# CITY OF ALBUQUERQUE

**Re: Baca Duplexes  
4421 12<sup>th</sup> St. NW  
Request Prmanent CO - Accepted  
Engineer's Stamp dated: 7-18-14 (G14D080)  
Certification dated: 10-7-15**

**Re: The Baca Duplexes**  
**4421 12<sup>th</sup> St NW**  
**Request Permanent C.O. – Not Accepted**  
**Engineer's Stamp dated: 7-8-14 (G14D080)**  
**Certification dated: 10-7-15**

GRADING & DRAINAGE PLAN

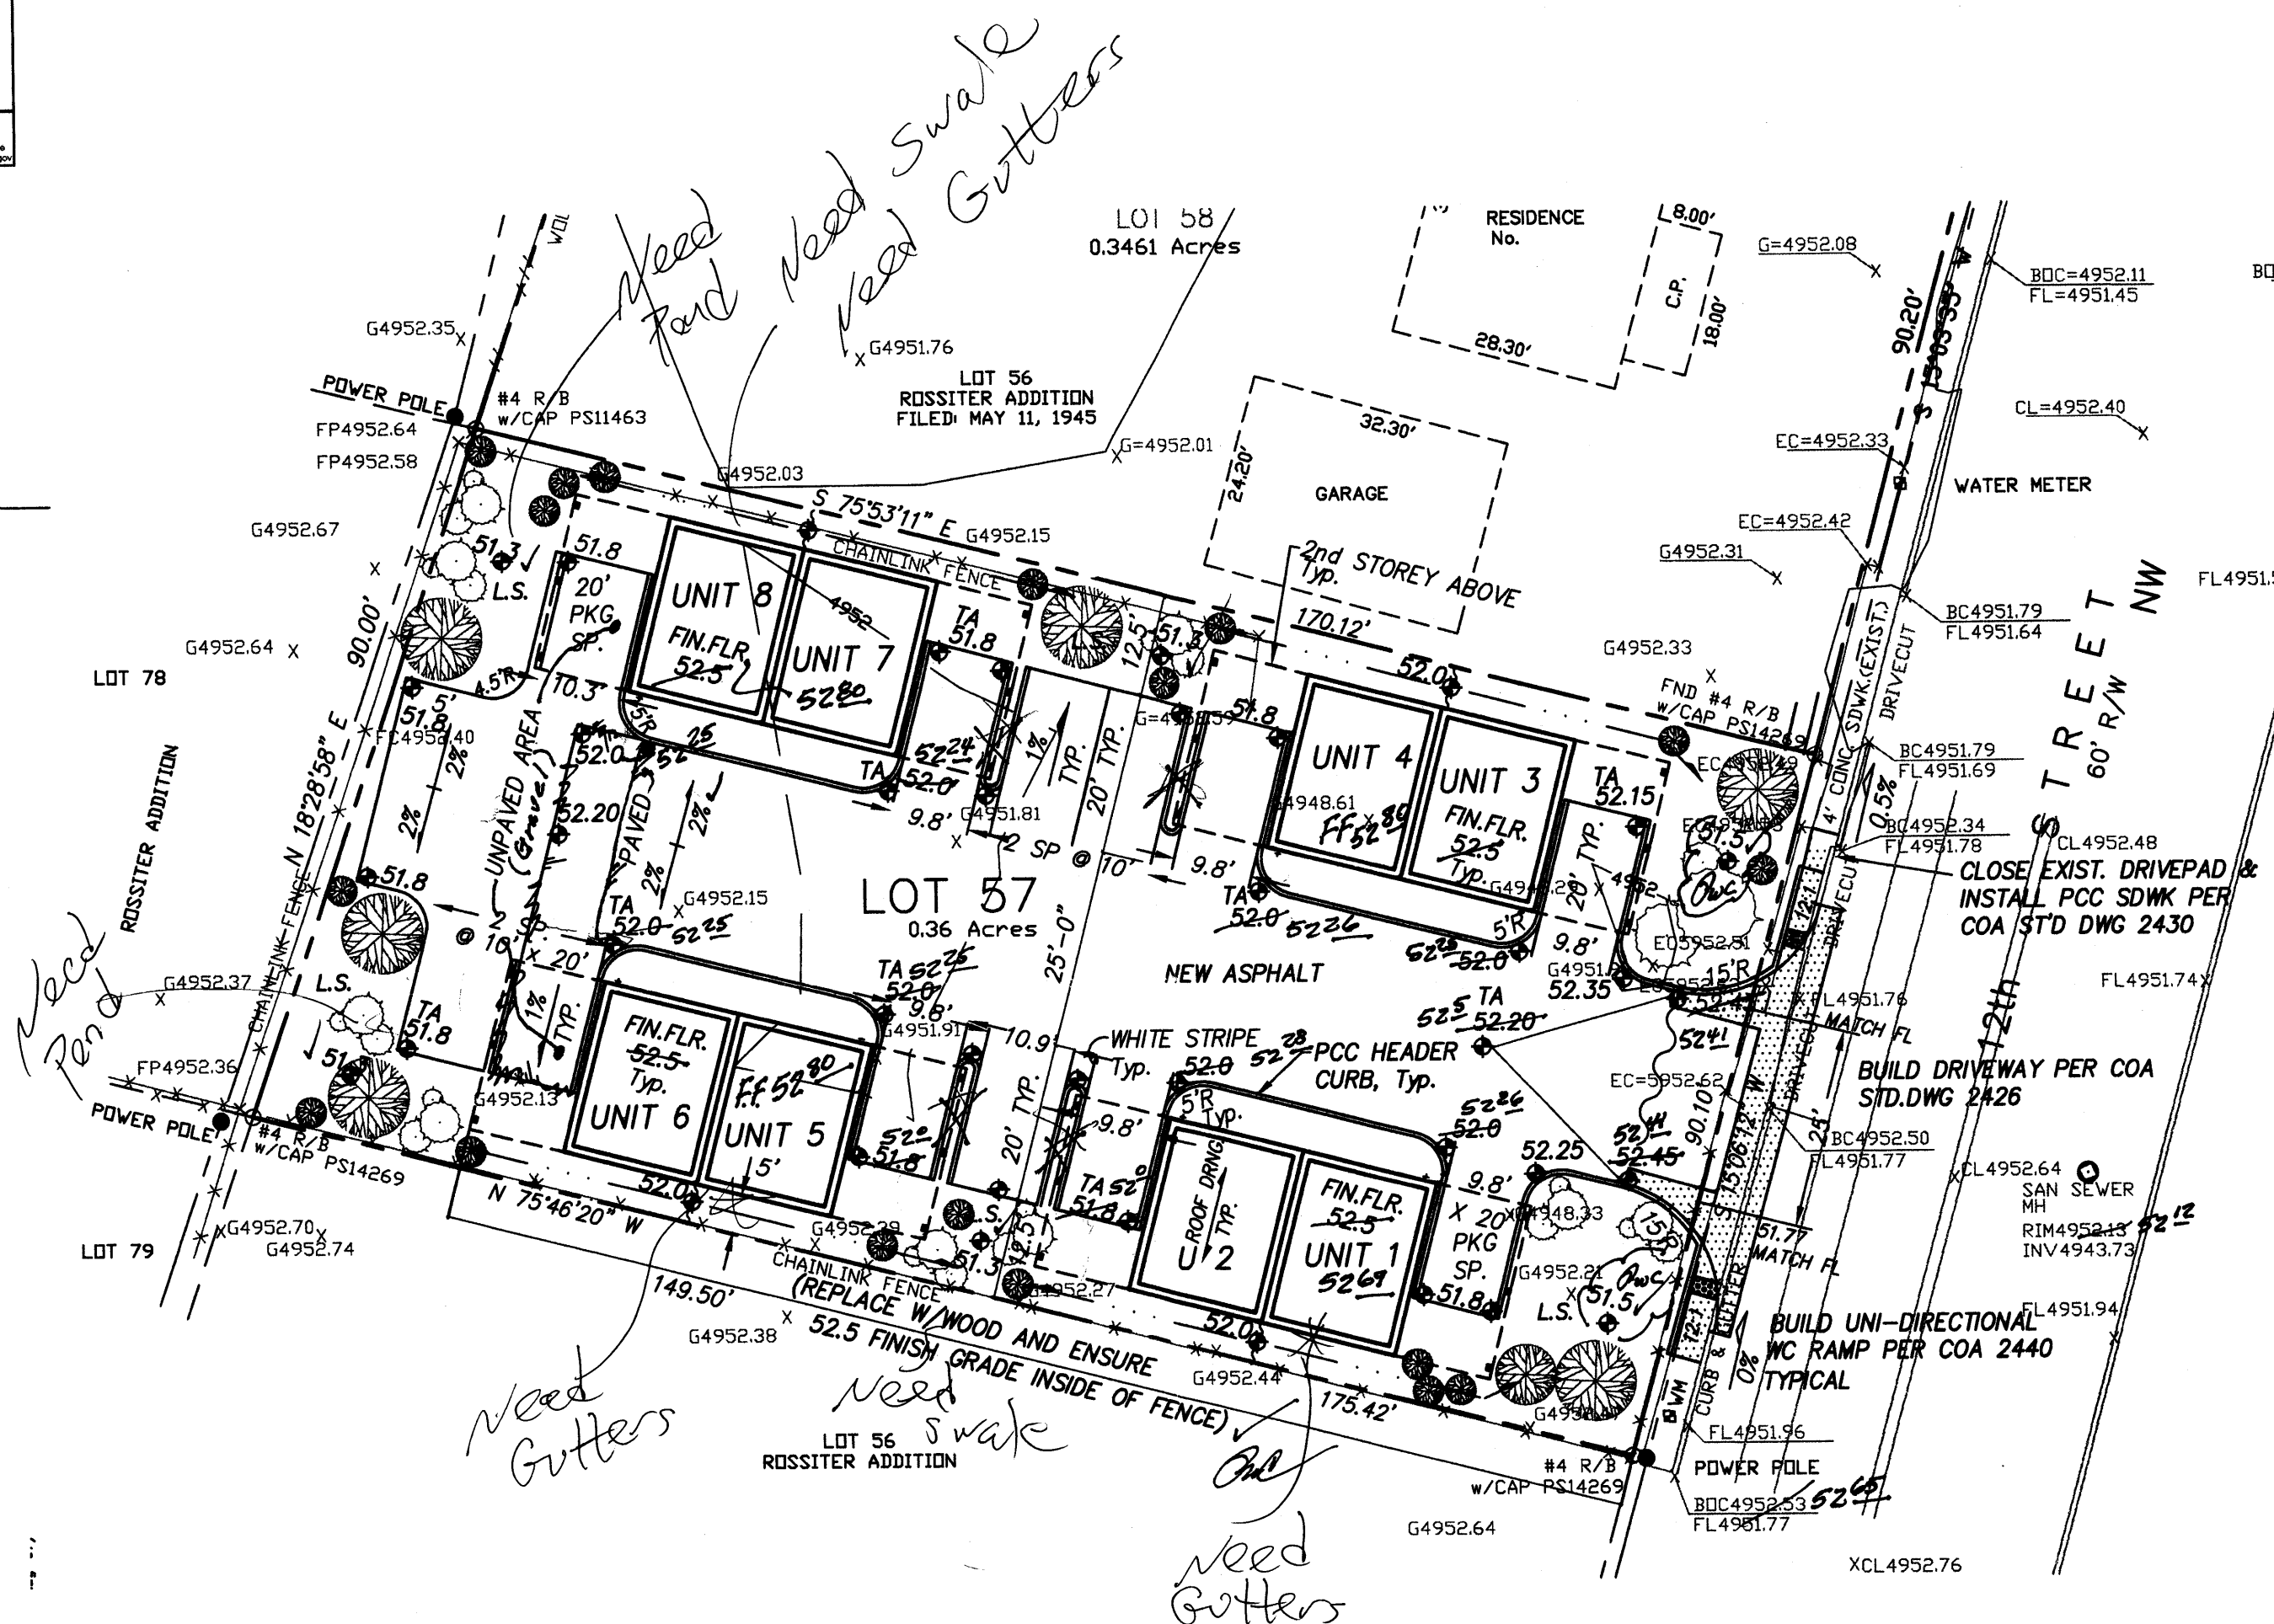
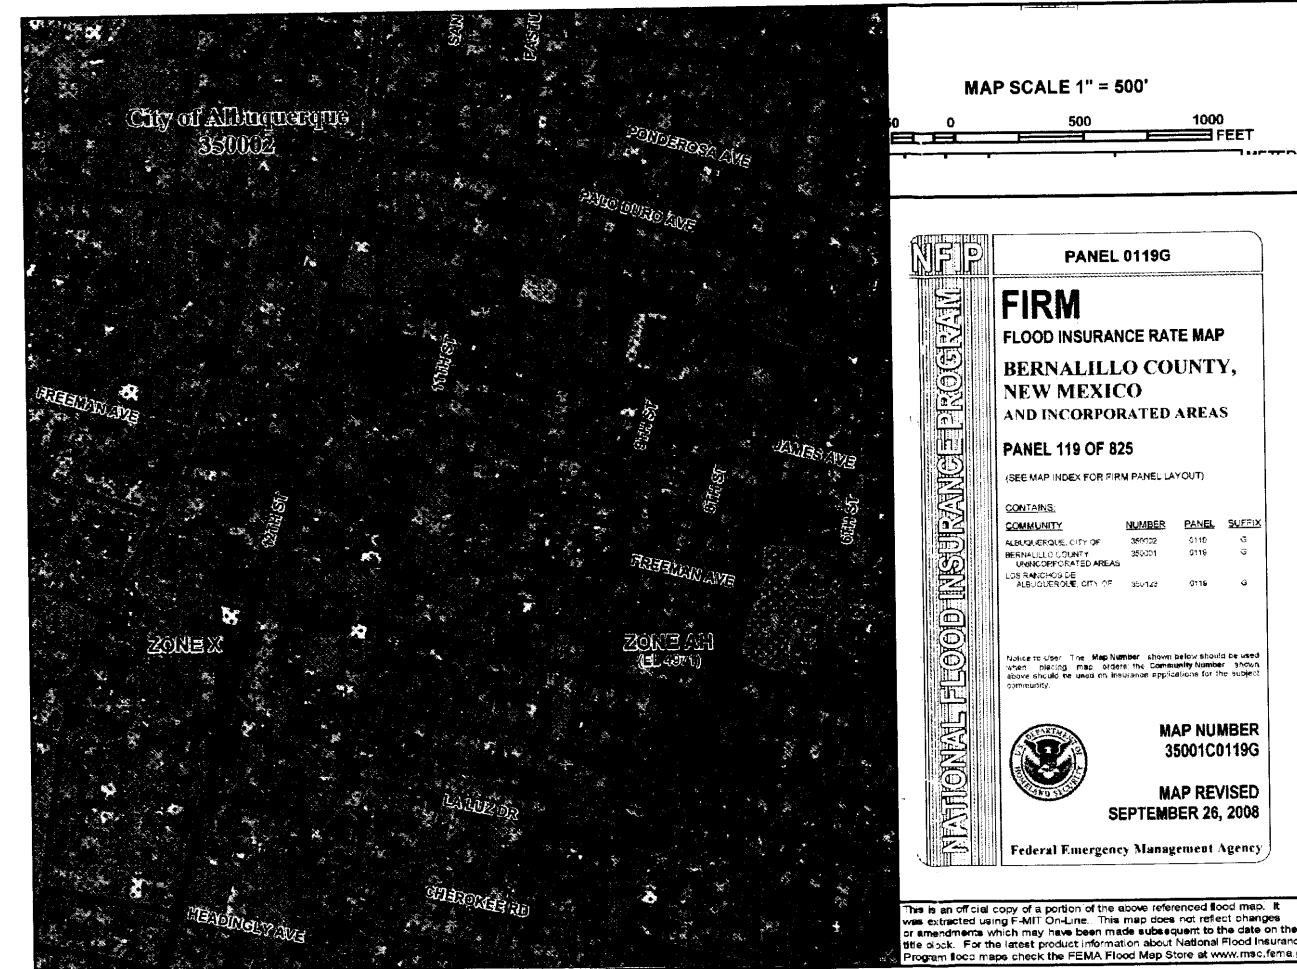
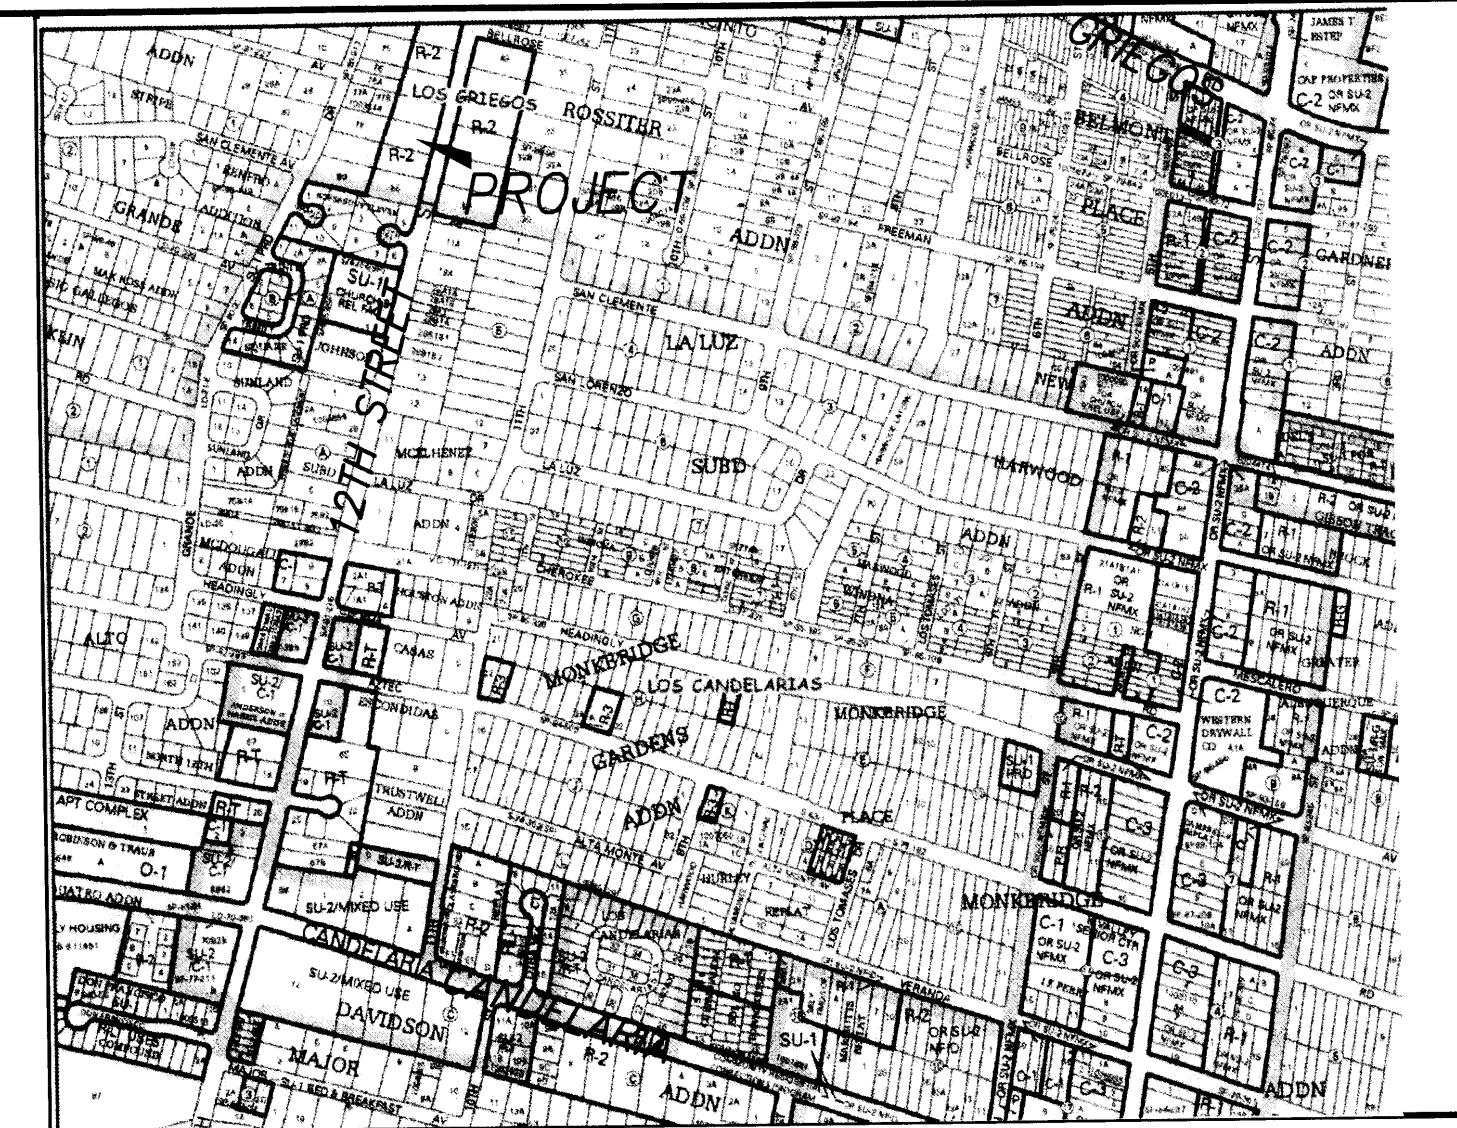
1. The site does not drain with substantial compliance; swales need to be added to the north and south of each duplex for drainage into ponds on the east and west.
2. Landscaping does not appear to be depressed.

DATE	REVISION	LOT 57 ROSSITER ADDITION ALBUQUERQUE, BERNALILLO COUNTY, NEW MEXICO 4421 12TH STREET NW THE BACA DUPLEXES (4) TRAFFIC CIRCULATION LAYOUT
10/12/15	As-Built	
DESIGNED BY: PWC	DRAWN BY: COE	JOB #: BBACA
CHECKED BY: PWC	DATE: JUNE 2014	FILE #: TCL

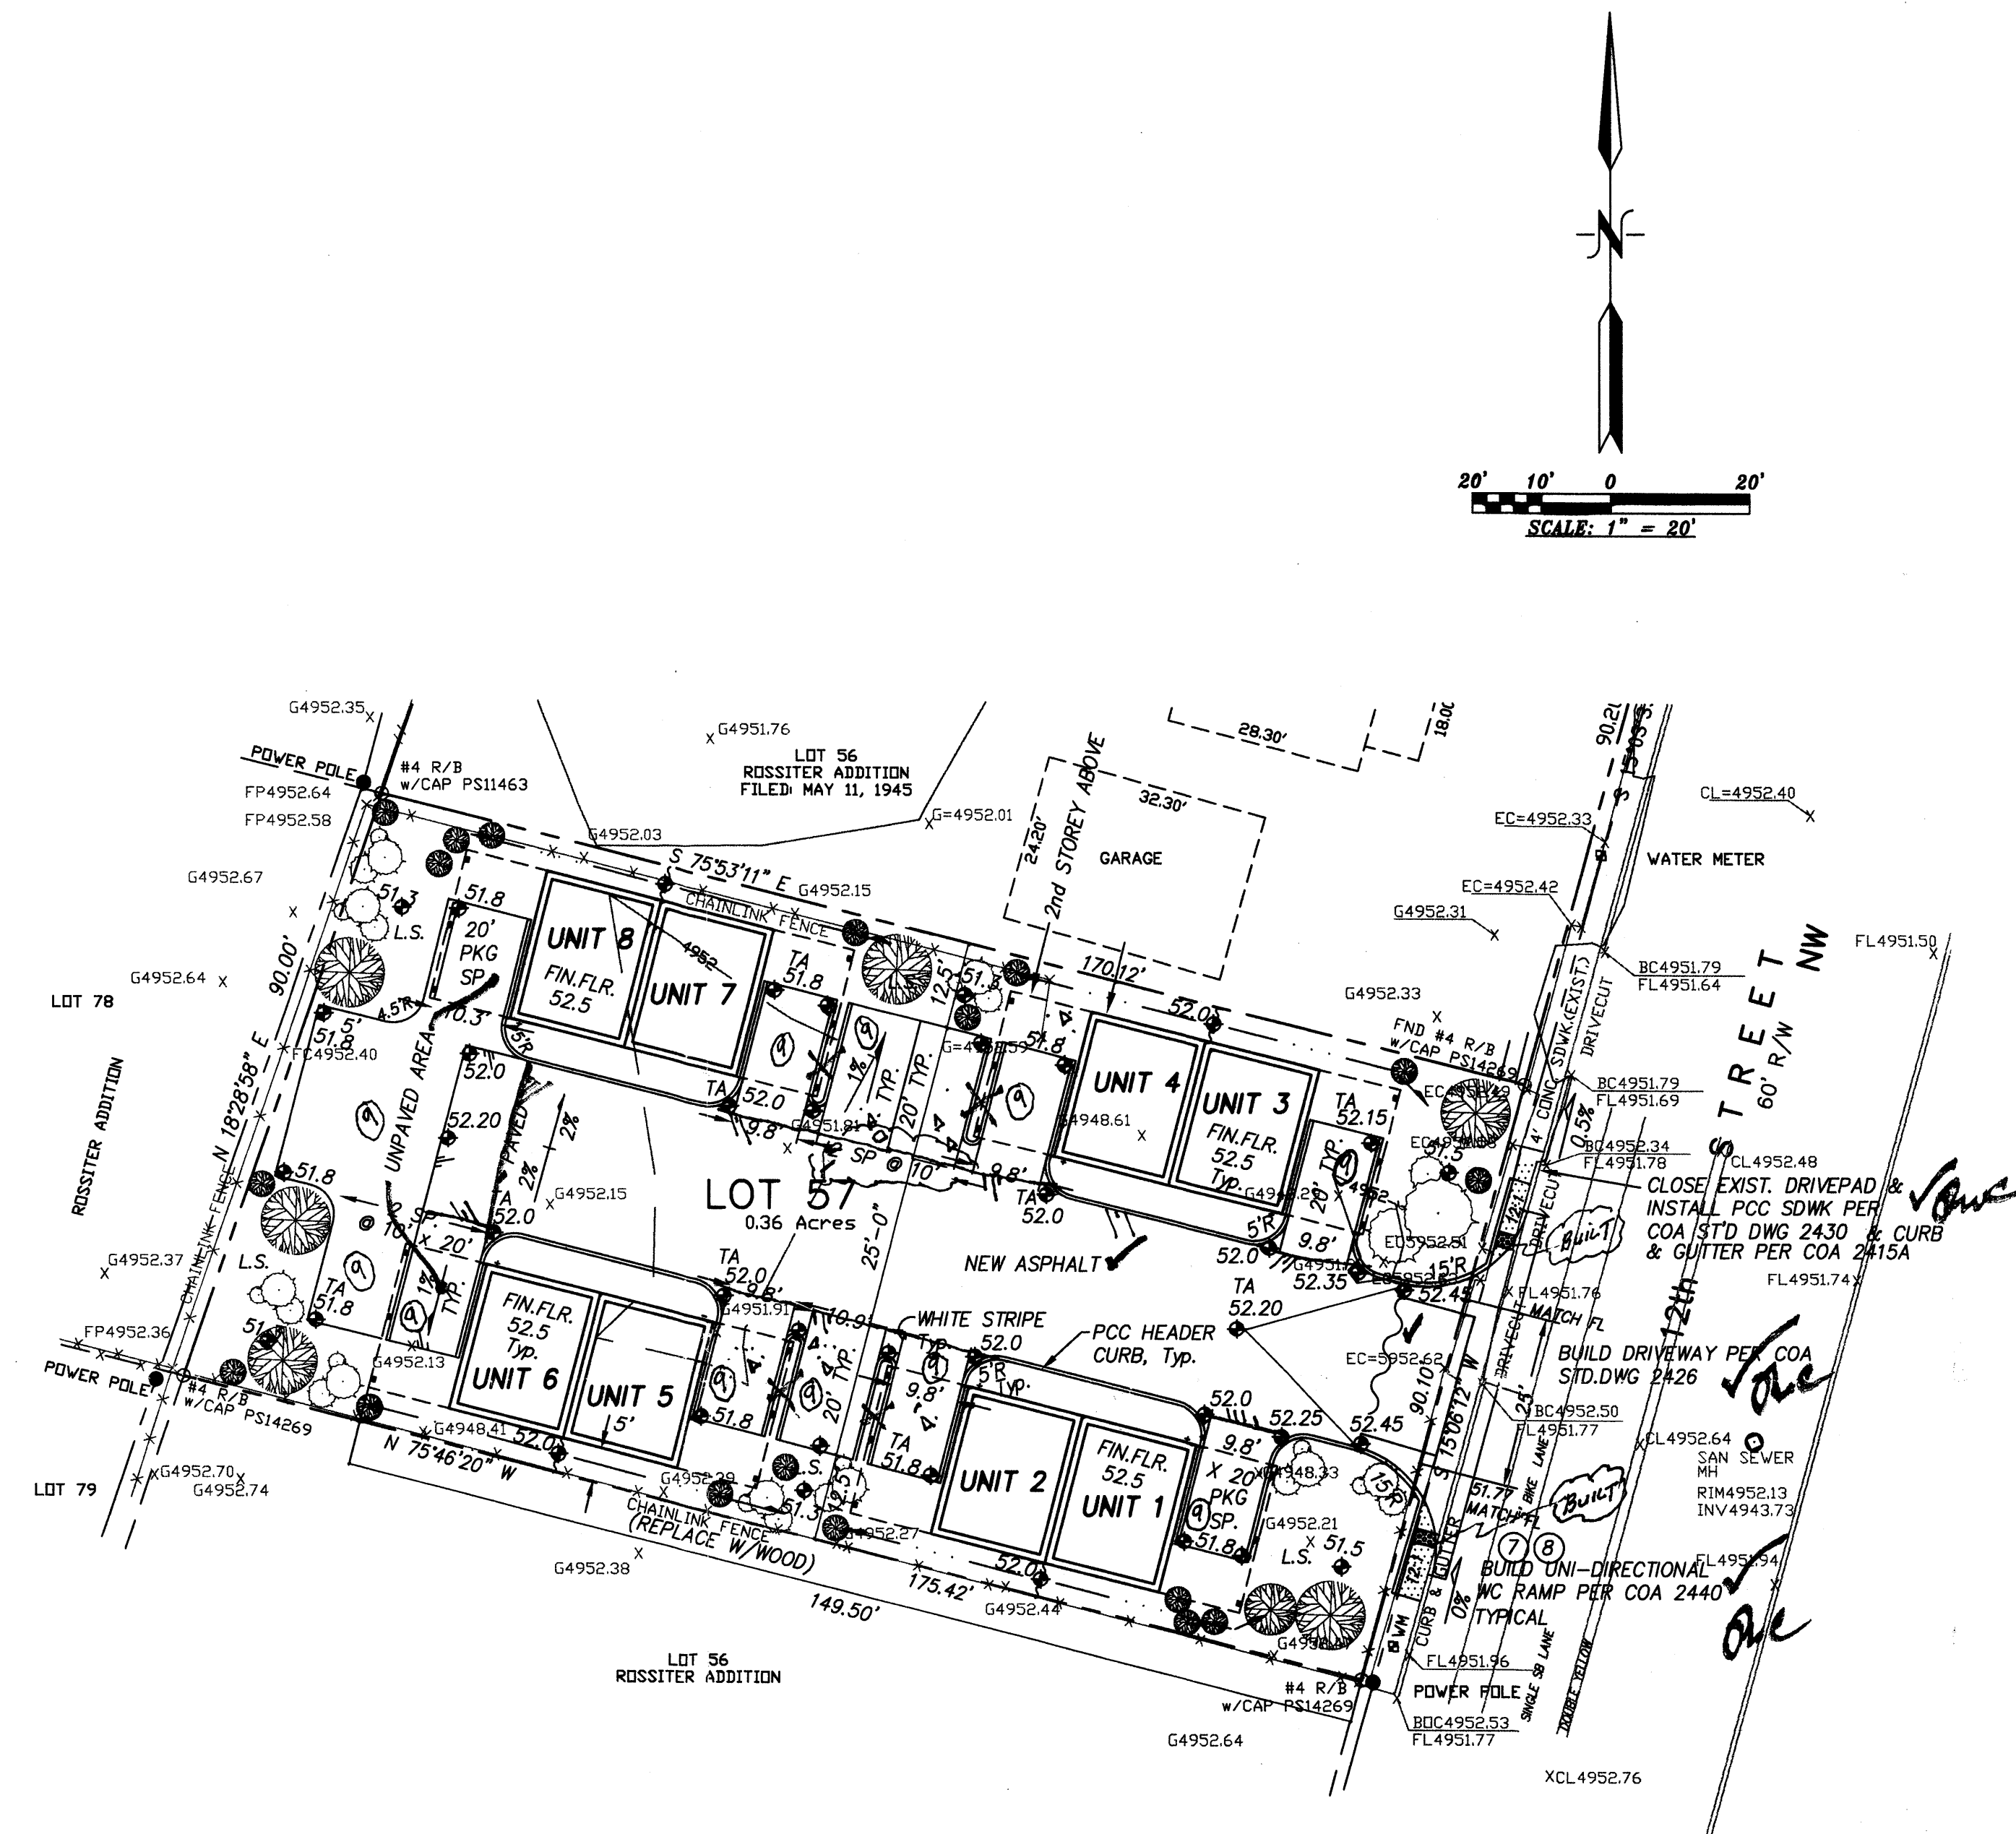
- Per approved plan, parking lot and spaces are to be of asphalt construction. Upon inspection, the parking spaces are not asphalted. Please correct at the project site or change drawings to specify parking surface.
- The approved plans state that 12 parking spaces are to be provided. Upon inspection the parking spaces between Unit #1 and Unit #4 are a total of 14 ft. wide by 20 ft. long, which will not provide adequate parking width for two vehicles. Please submit updated parking lot layout.
- PCC Header Curb on parking lot has not been constructed, as called out on approved plans.
- Truncated Domes at Public R.O.W. handicap sidewalk ramps have not be installed per approved plan.
